Our ref: Americold Prospect Expansion (SSD-9577613)

21 December 2022

Subject: Additional Matters for Submissions Report - Americold Prospect Expansion (SSD-9577613)

Title:	CUT & FILL DEPTH PLAN
--------	-----------------------

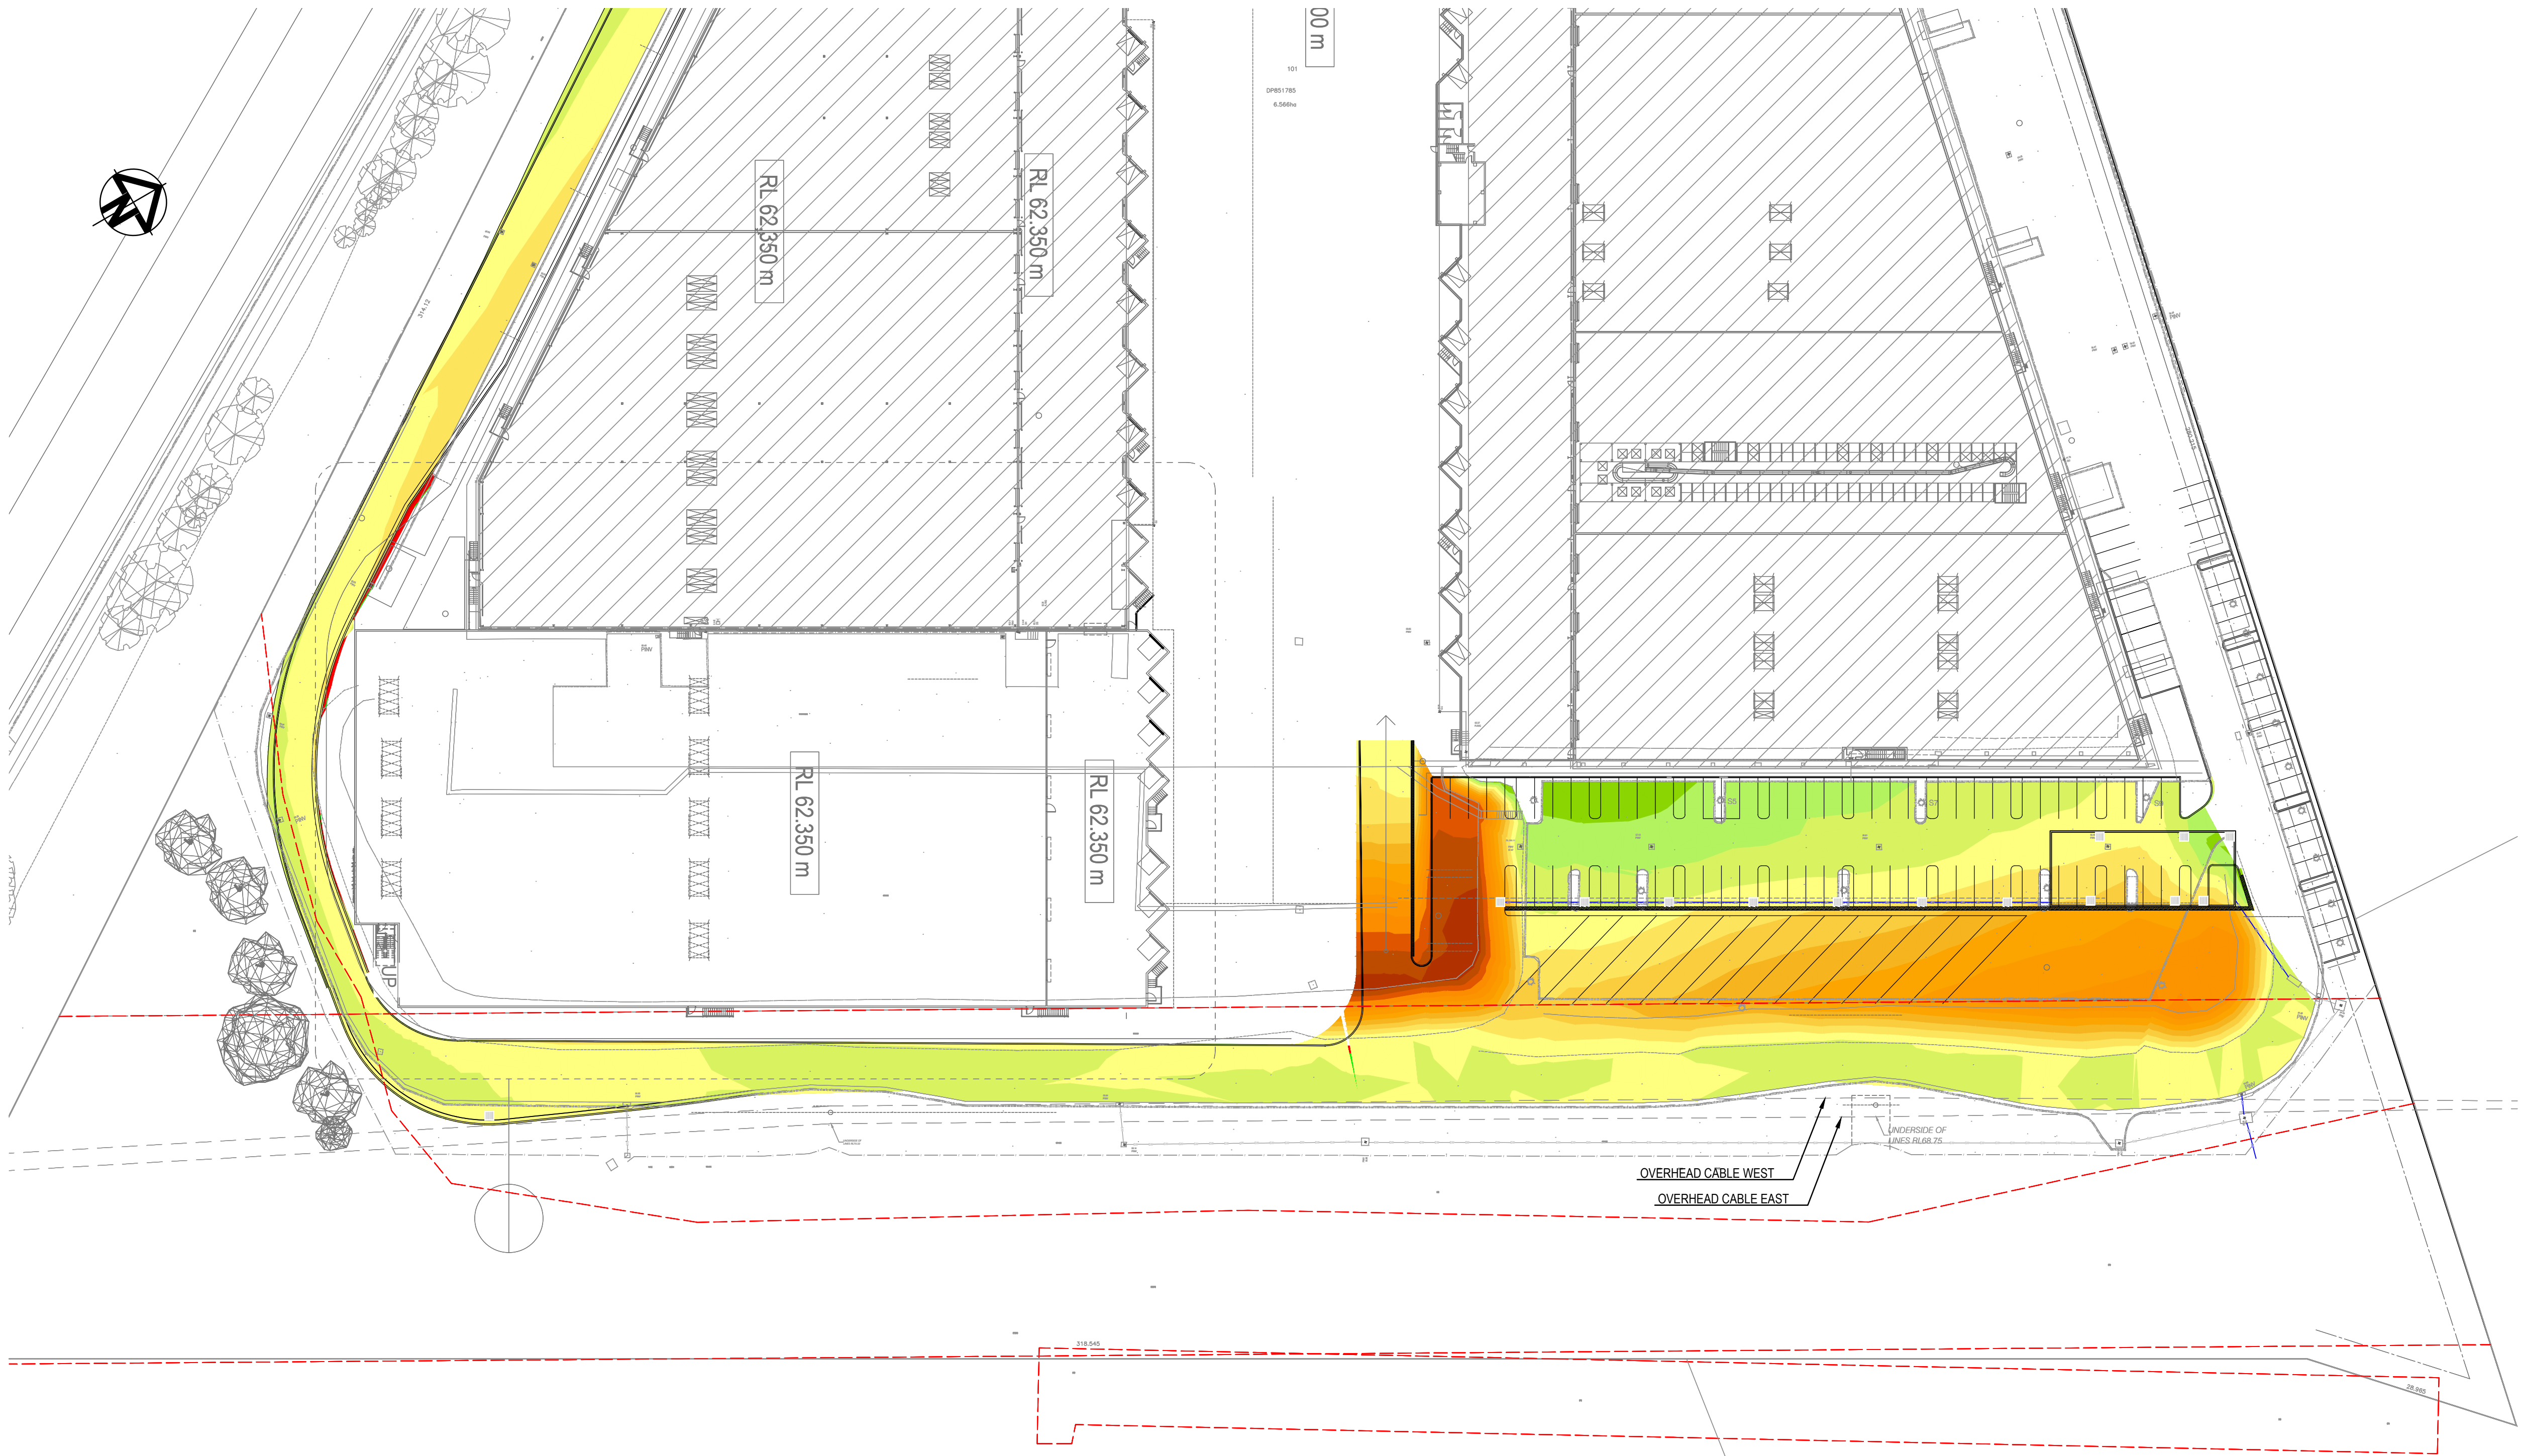
10. The flood study provided does not appear to specifically reference if the proposed cut and fill in the eastern part of the site adjacent to the creek line along the eastern boundary has been considered. Please clarify that this information was included in the assessment of flood impacts.
